From: Gregg, Robert <Robert.Gregg@lancashire.gov.uk>
Sent: 22 February 2019 12:17
To: Rebecca Bowers
Cc: planning; LHS Customer Service
Subject: APP. 3/2019/0077 - 67 FAIRFIELD DRIVE, CLITHEROE

Removal of existing garage and replacement with new single-storey storage/outbuilding to the rear.

PROPOSED POSITION / OUTLINE OF NEW BUILDING.

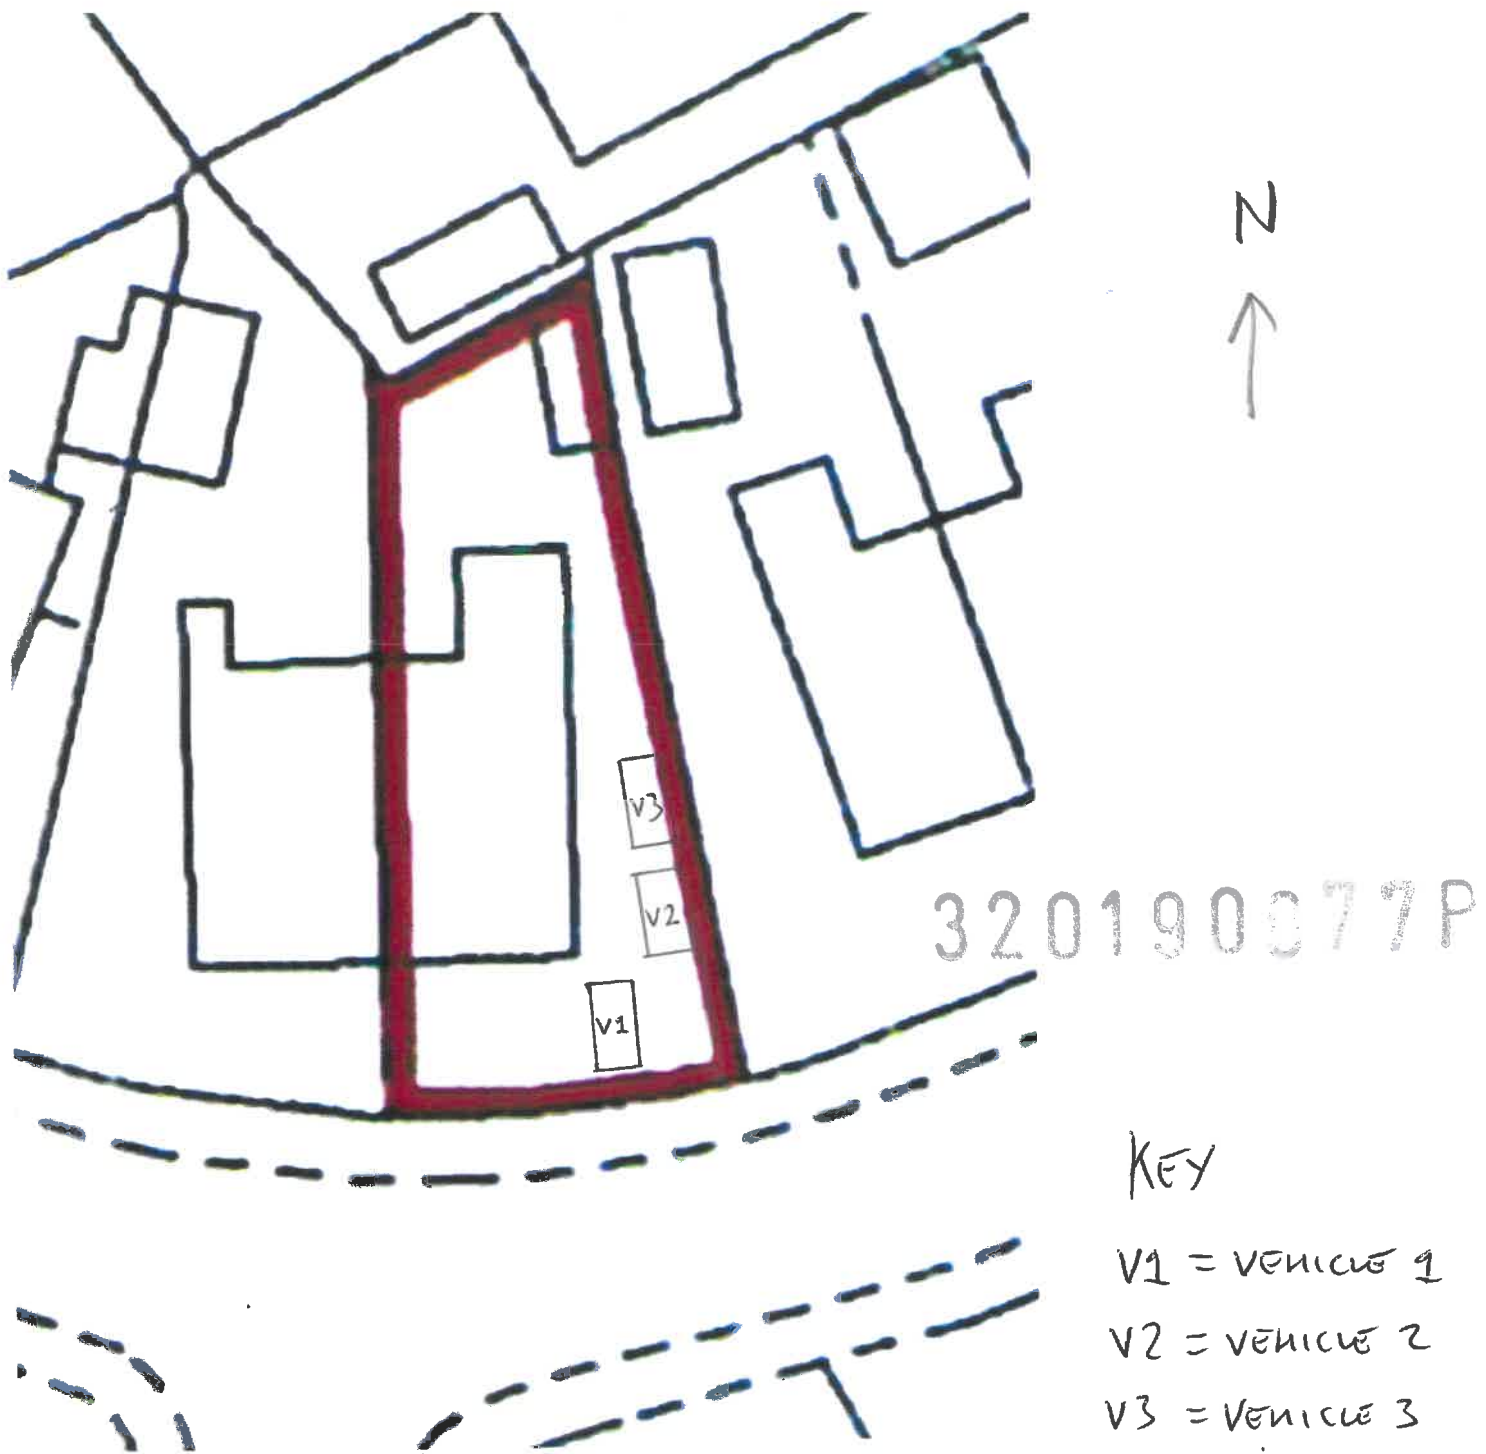
With respect to the above application, whilst I would raise no objection in principle I would require a revised plan which would indicate the parking arrangements as a result of the proposal.

The application states that the parking arrangements as detailed in the site plans are used each day, although this parking configuration is considered to be insufficient in terms of practicality, as manoeuvrability would prove difficult for vehicle 1 and 2 in accordance with the proposed site plan, due to the boundary wall and gated entrance. As such, the application could lead to a reliance for on-street parking to the detriment of highway safety and residential amenity, therefore I would require the parking configuration to be revised.

If tandem parking is proposed, then a distance of 18m would be required to accommodate this. However if the applicant wishes to proceed with the parking configuration as laid out, in accordance with the proposed site plan, then the boundary wall will need widening to create an access point of 5.6m. Subsequently an extension to the existing dropped crossing will need to be constructed, whereas this work will need to be carried out under section 184 of the highways act 1980.

I ask the plans be revised.
